3rd January 2019

Removal of shrubbery (15' high x 20' deep) at front of property and erection of boundary wall to replace (Retrospective)

36 Gossamer Lane Aldwick

FRONT ELEVATION

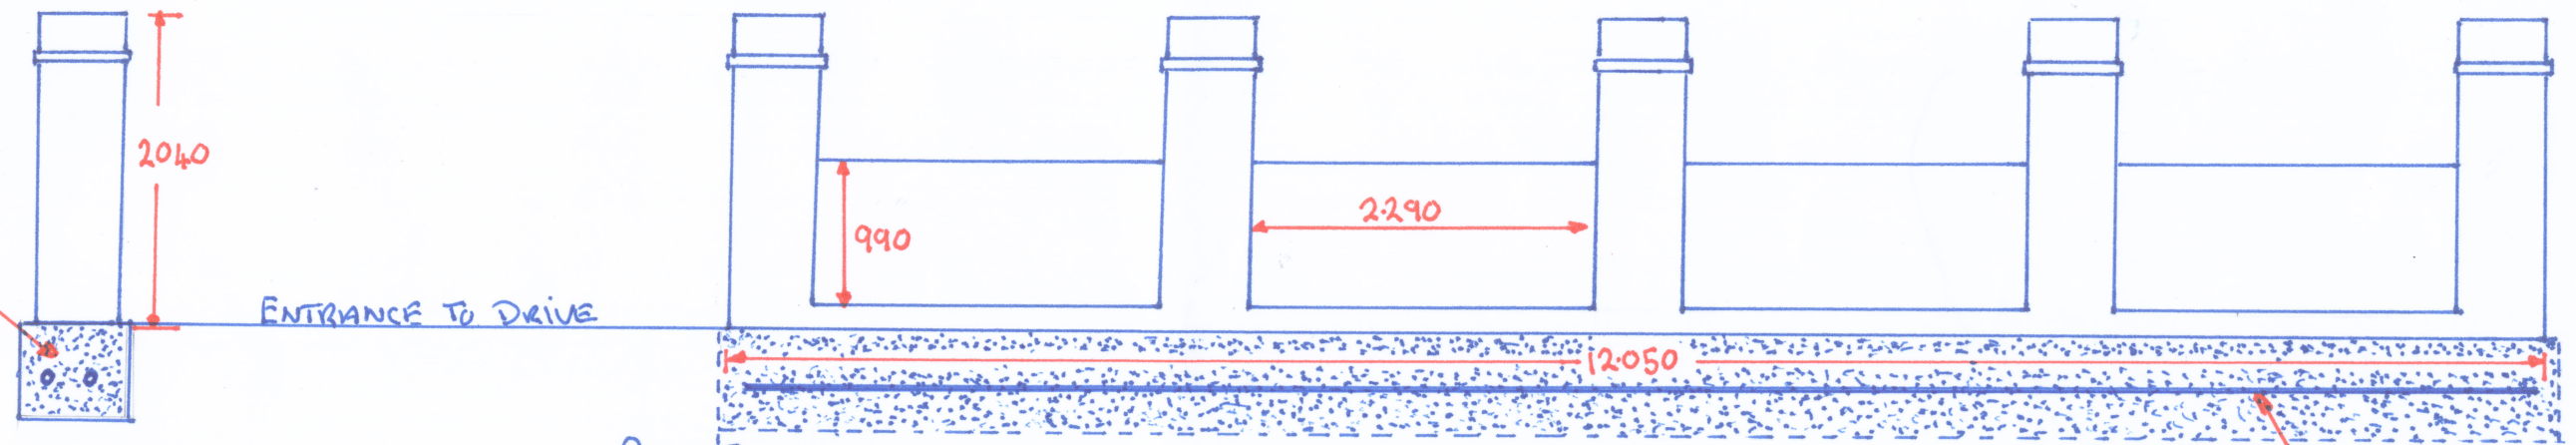
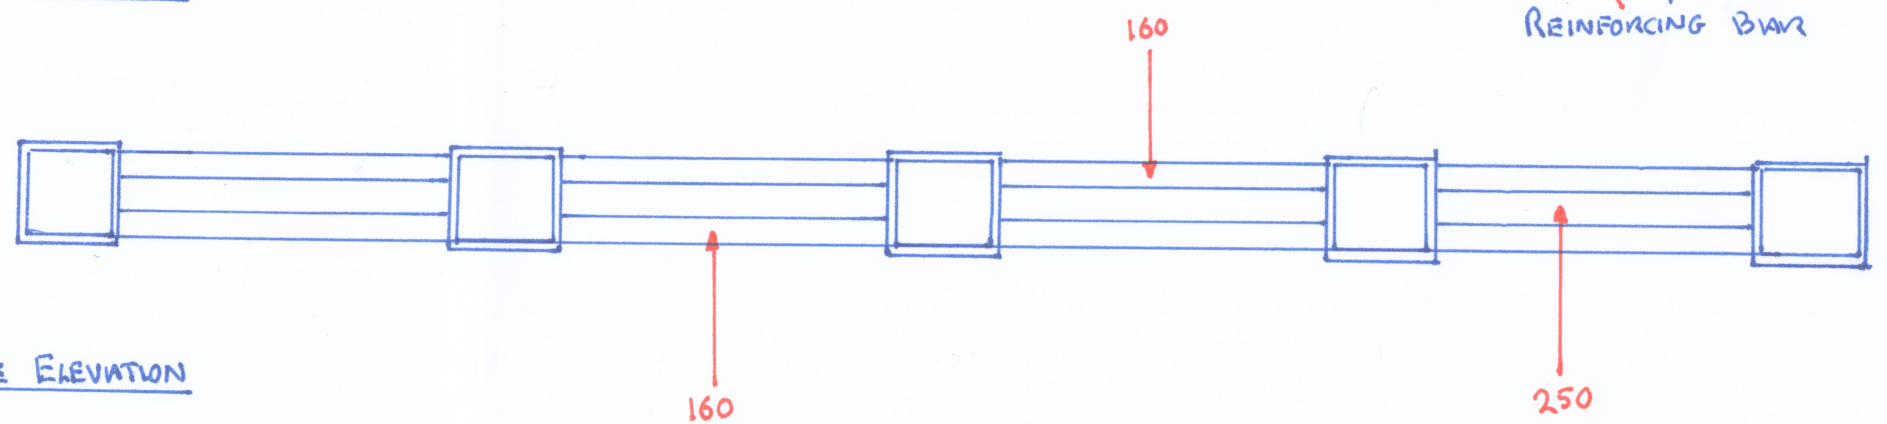
I object to the new wall based on the size as it is not in keeping with the rest of the properties along Gossamer Lane. The wall is far to large and also painted white. I live opposite the house and feel this will damage the value of my property as the general feeling is the wall is an eyesore. I would be happy with a wall of a similar size to mine or other properties and be built in brick rather than blocks and painted white. The size is far higher than anything in the surrounding area
